From: Simon Davis
Sent: 12 March 2020 14:56
To: 'Ben Daines'
Subject: RE: BE/137/19/RES The Cottage, Shripney Road

Drawing Title
Detailed Site Plan

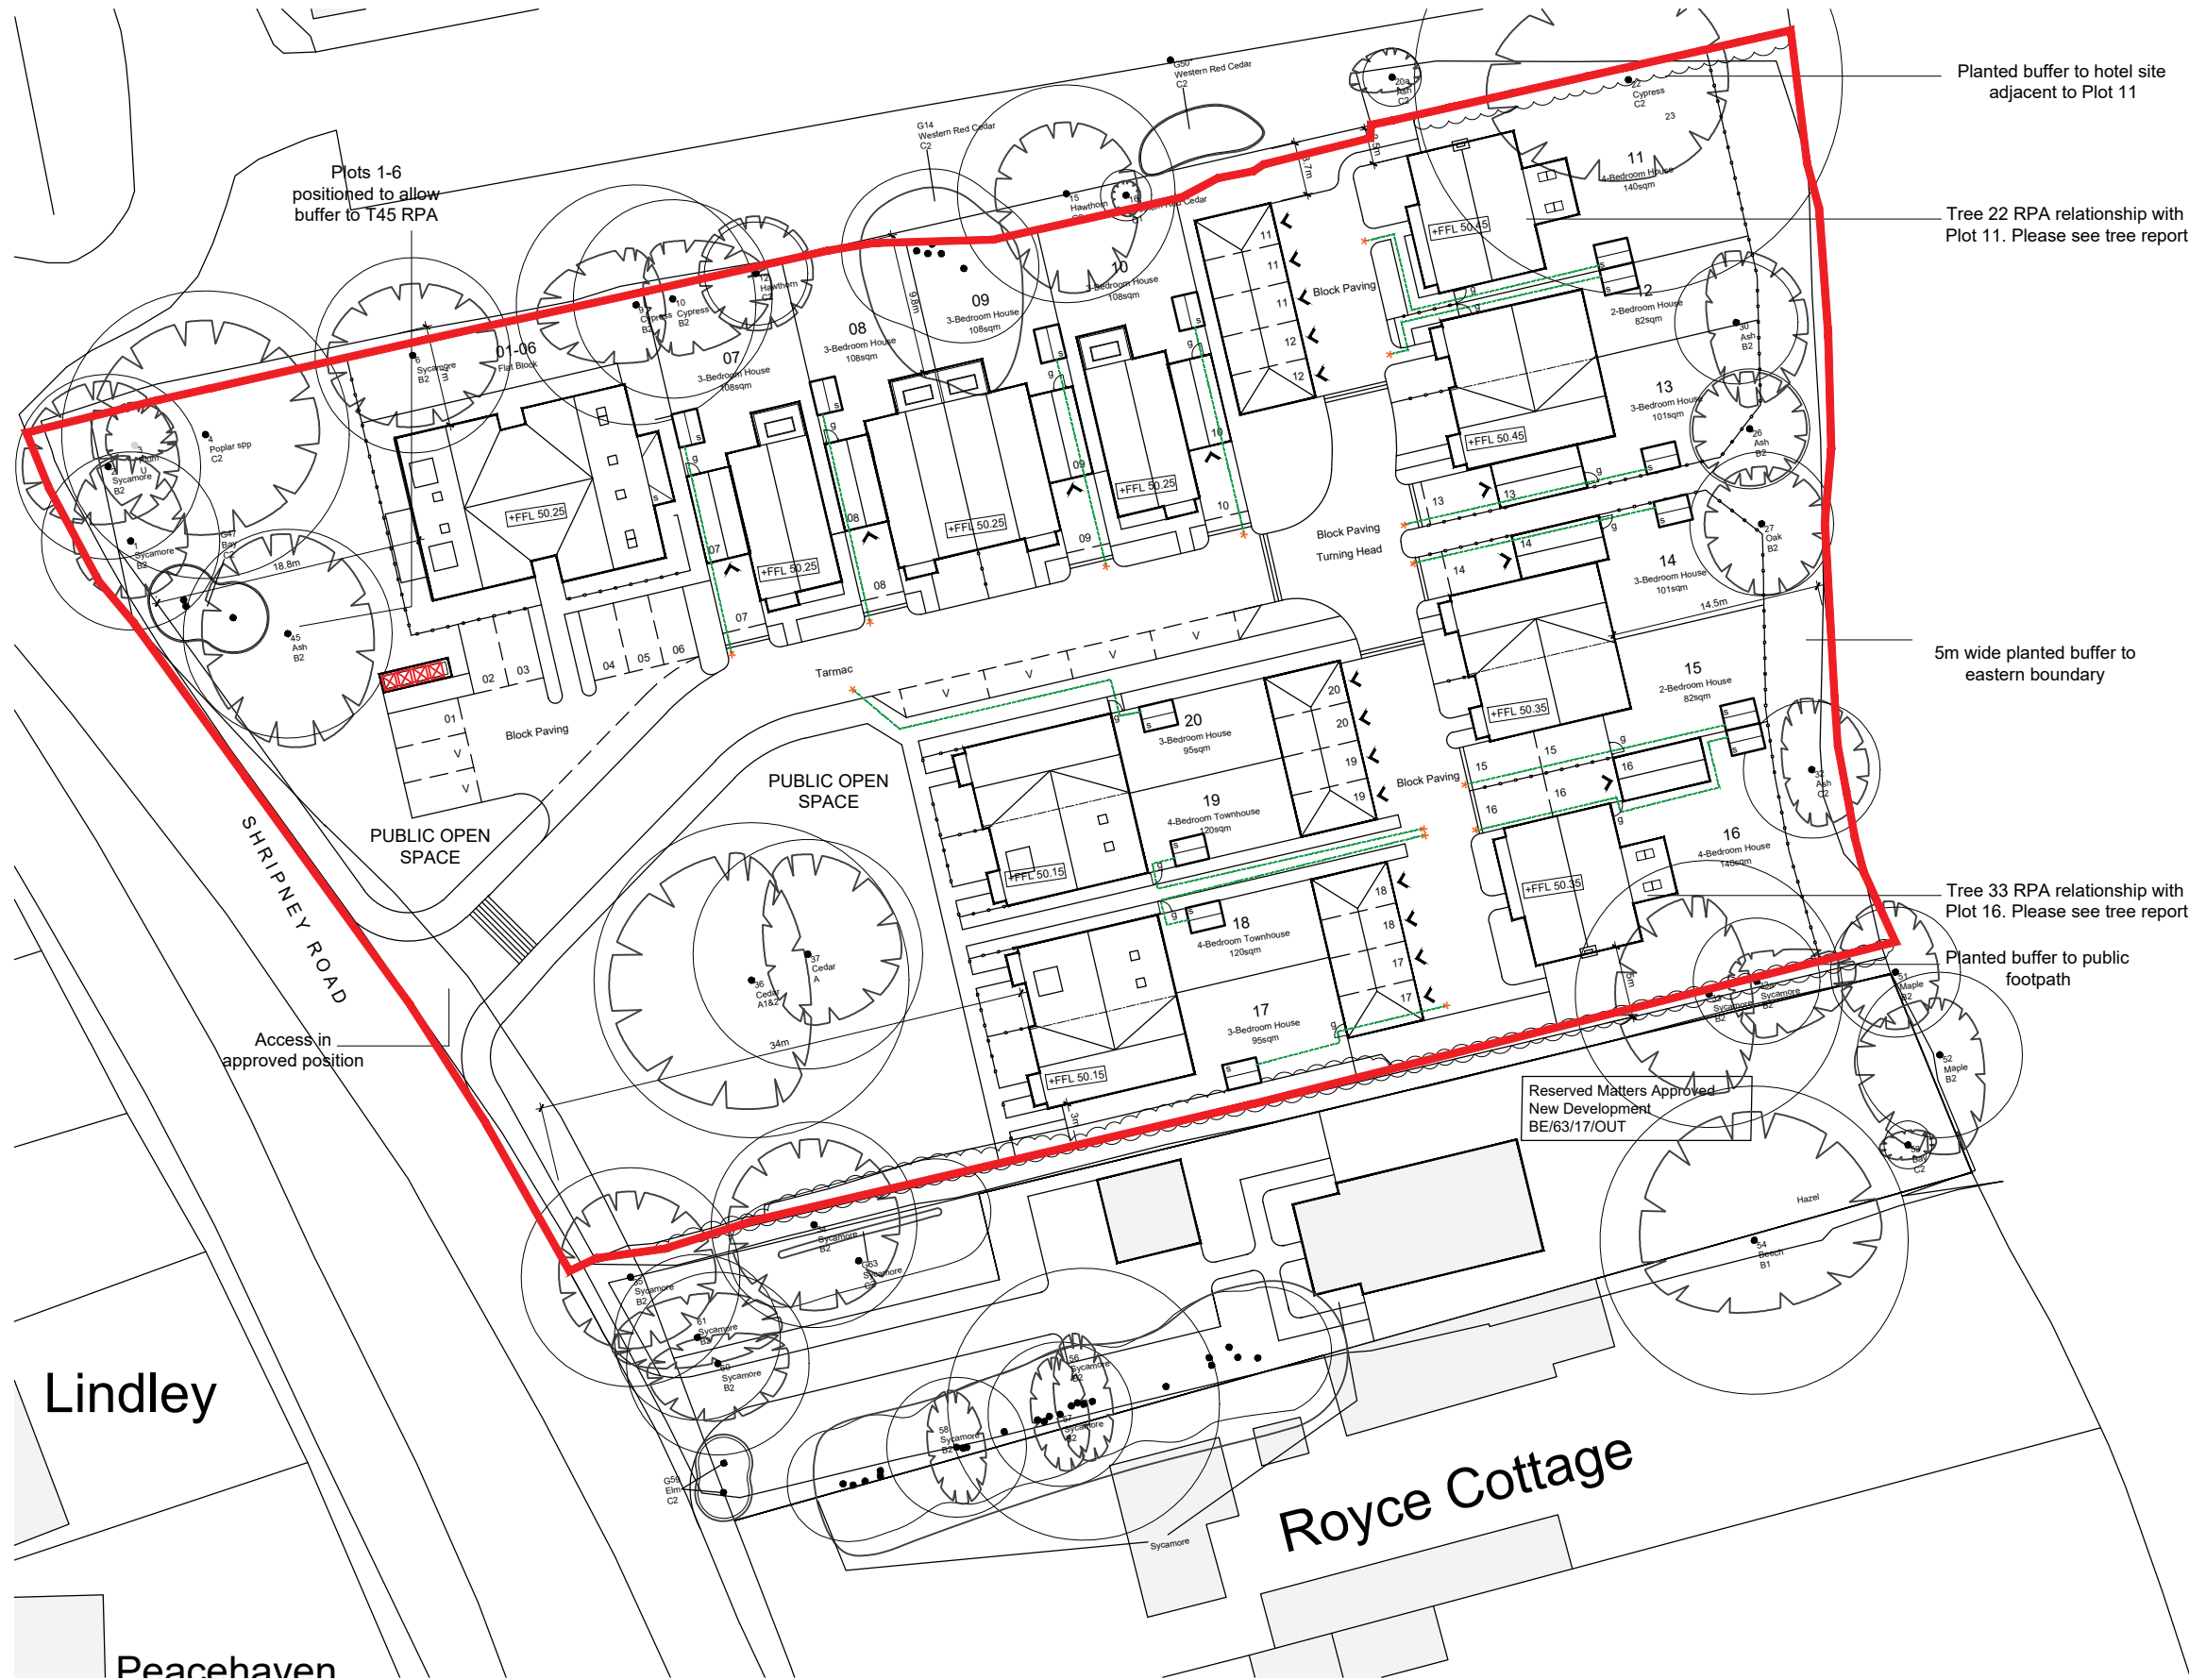
You can ignore my comments about B & C on the annotated plan. Our Greenspace Officer has no objection to the inclusion of these small linked spaces. However, the comment about area A remains.
